Markup Summary

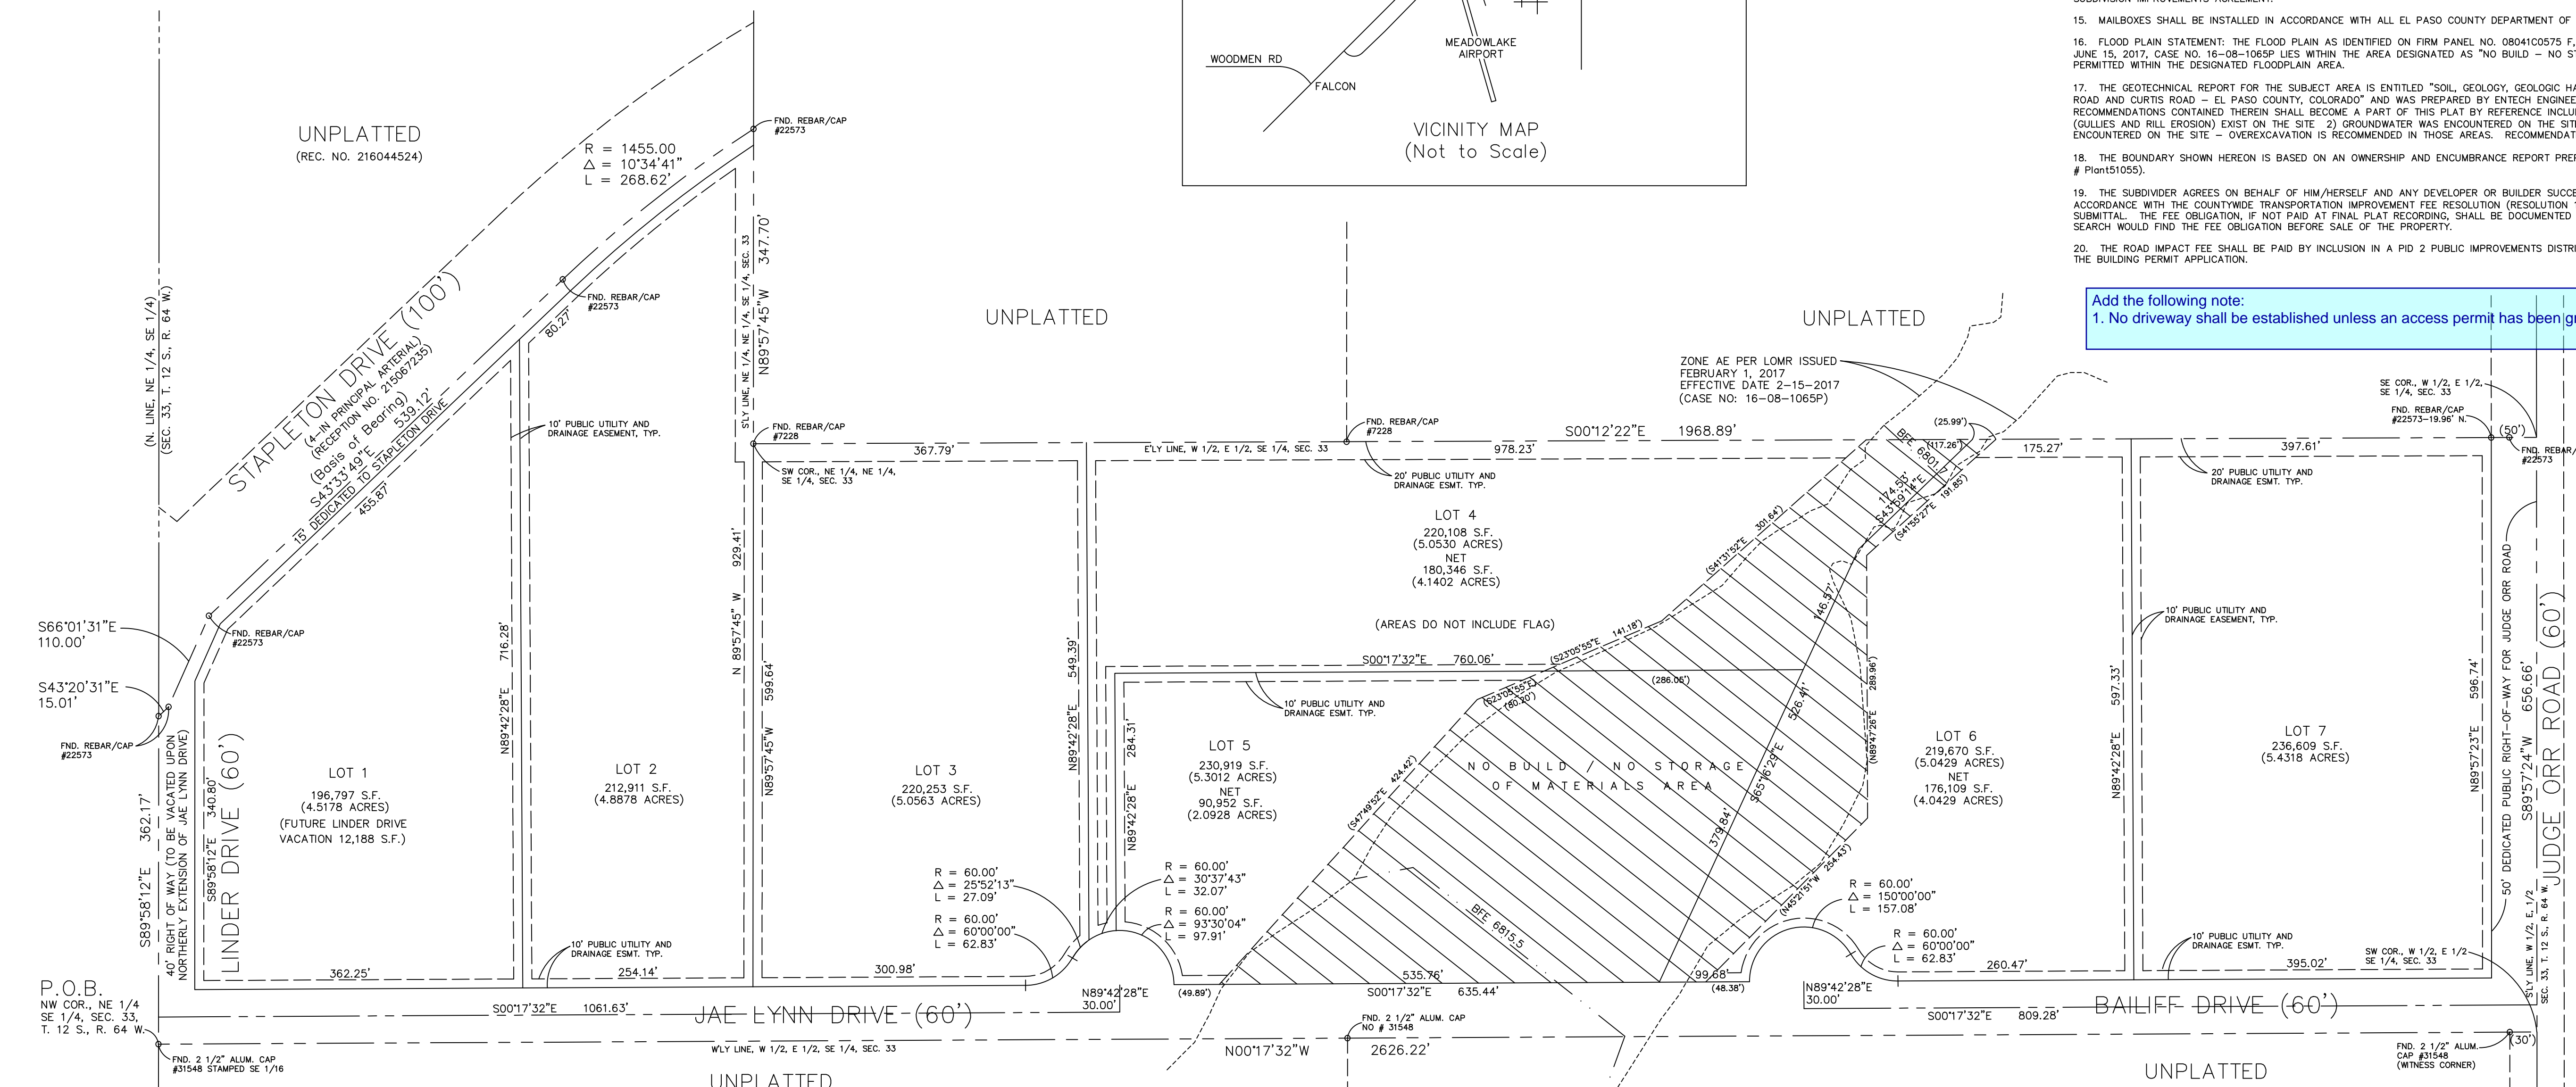
Revise to a ROW (transition from ROW-to-Easement-to-ROW is not allowed). The note may remain in place. Update the preliminary plan to reflect this comment

Add to note 18:
No structures are permitted within designated Floodplain areas

"No Build and No Storage of Materials"

Add the following notes:
- The addresses exhibited on this plat are for informational purposes only. They are not the legal description and are subject to change.

The 2040 MTCP identifies this as a 4-In Principal Arterial (130' ROW). Therefore, dedication of 15 additional feet of ROW is required.

Identify the geologic hazard. The Geotech noted potential seasonal high ground water. Identify the specific lots or location of area.

No Build / No Storage of Materials Area

Show the approved base flood elevation

Add the case number and double check the effective date of the LOMR

Revise note 15 to:
 All property owners are responsible for maintaining proper storm water drainage in and through their property. Public drainage easements as specifically noted on the plat shall be maintained by the individual lot owners unless otherwise indicated. Structures, fences, materials or landscaping that could impede the flow of runoff shall not be placed in drainage easements.
